From: Anita Gardner [REDACTED]
Sent: 04 June 2020 19:09
To: Planning.Responses <Planning.Responses@arun.gov.uk>
Subject: FW: A/34/20/DOC - Mayflower Way, Angmering - Compliance with Condition 16 Contamination.

Figure 3 – Trial Hole Plan

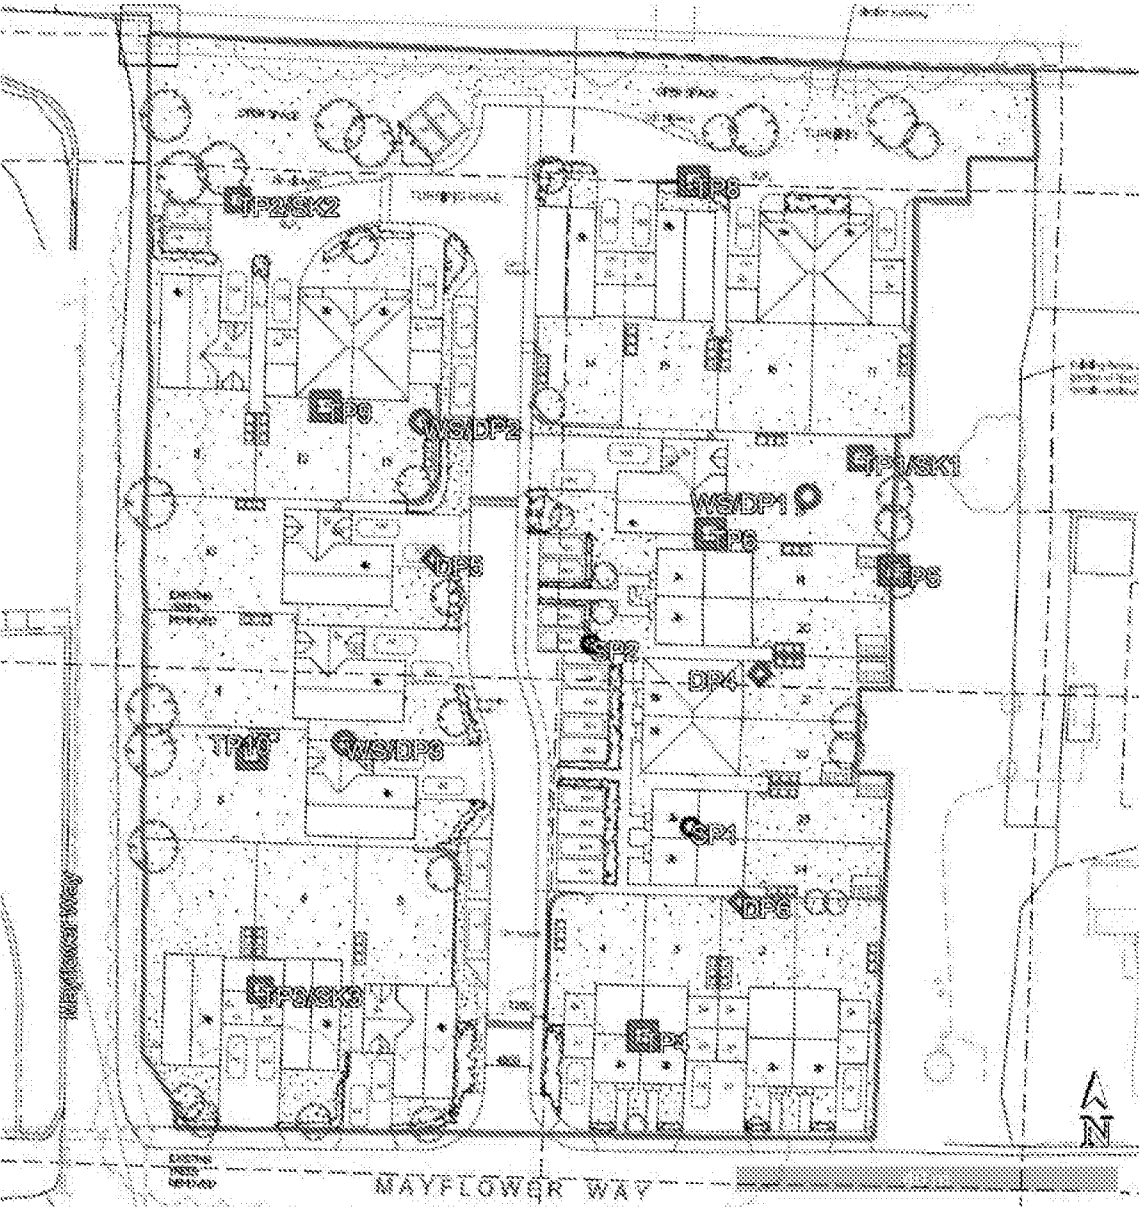
It is understood that the trial pit where the elevated concentration of lead was identified has been excavated and covered by hardstanding. It is of concern, however, that no further testing was undertaken in the garden areas of the plots in question. Excavation and imported certified clean material is a valid method of remediation, however we would expect to see a minimum of 600mm removed and replaced or a depth of 300mm removed and placed but with the addition of a geotextile membrane. If the applicant can confirm that either of these options have been met, this will be considered satisfactory. If not, it is recommended that further sampling is undertaken in the garden areas/areas of soft landscaping of the plots in question. The sampling strategy may include any areas of soft landscaping to the front of the plots in question. A suitably qualified, independent consultant should be engaged to further advise on the required sampling regime.

- the CGIR identified an exceedance of lead at 0.10 metres depth and stated that based on the proposed development plan, no remediation was required, however

no management of this exceedance is mentioned and no subsequent sampling of the garden areas was undertaken;

Therefore, it is my understanding that the area where elevated concentration of lead was identified is in the proximity of plots 6 & 7.

It is therefore our intention, at the appropriate time during construction when we have the correct formation level, to test the front and rear gardens of both of these plots. If these results come back ok we will just cap with 300mm topsoil as we would normally, however if they do not we will ensure a 600mm capping layer or 300mm and geotextile is installed accordingly. We will then demonstrate this via discharge of part 4 of the same condition.

The area where the elevated lead concentration was encountered was beneath the proposed buildings of plot 6 & 7 and at shallow depth. The attached drawings show that site levels were to be reduced in this area by between 200 and 300mm and therefore the encountered lead would have been removed during construction and, even if present at greater depth, would have been covered so that it would not present a risk to the end-user. With regards to the garden areas of plots 6/7, it is acknowledged that no supplementary sampling testing has been undertaken, however, given the proposed site level changes across these garden areas along with the need to replace the surface soils with an appropriate growing medium / topsoil then the same would apply to these areas i.e. removal of material to facilitate level change and further replacement of near surface soil with imported clean material.

SOIL GAS PRESENT : YES

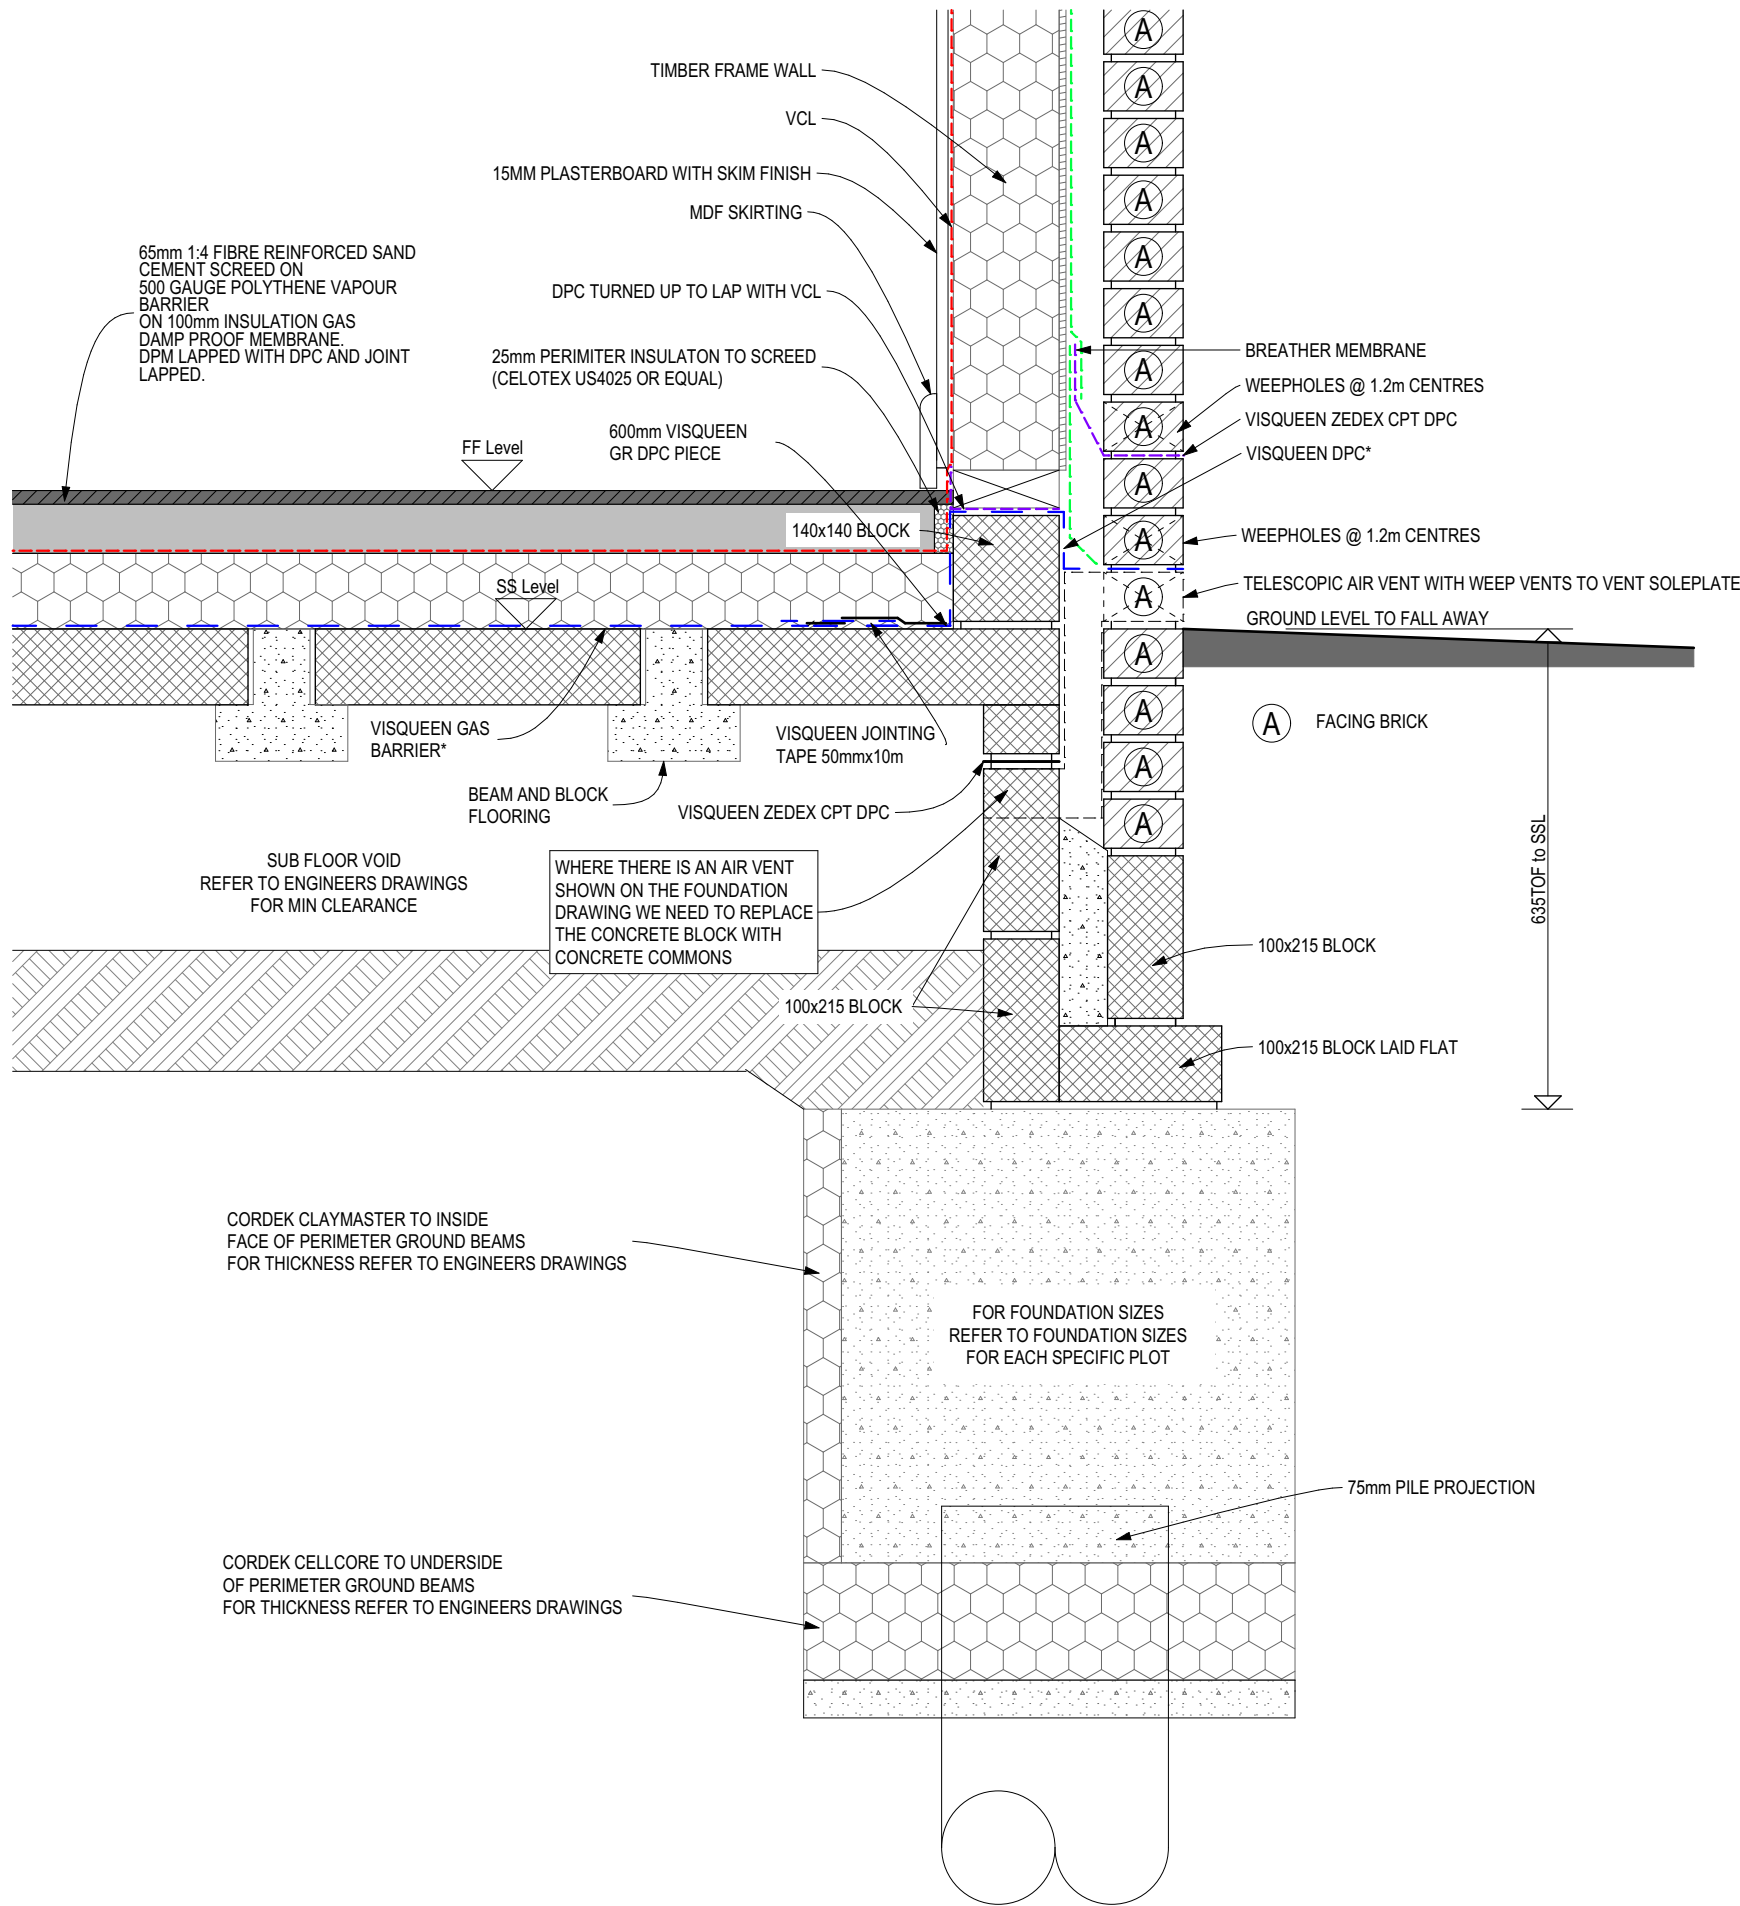
With regard to the gas membrane, if the applicant can confirm that this has been/will be fitted to all properties, this will be considered satisfactory.

- 2) the SGRA concludes that gas protection measures are likely to be required, however no detail is provided.

- the SGRA concludes that gas protection measures are likely to be required, however no detail is provided.

Firstly, I can confirm that the gas membrane detail will be utilised across all plots of the site.

I have attached our standard gas membrane detail for these situations as requested in their email.

The Local Authority should be provided with the appropriate cross section drawings relating to the gas membrane installation along with details of the intended membrane to satisfy CS-2.
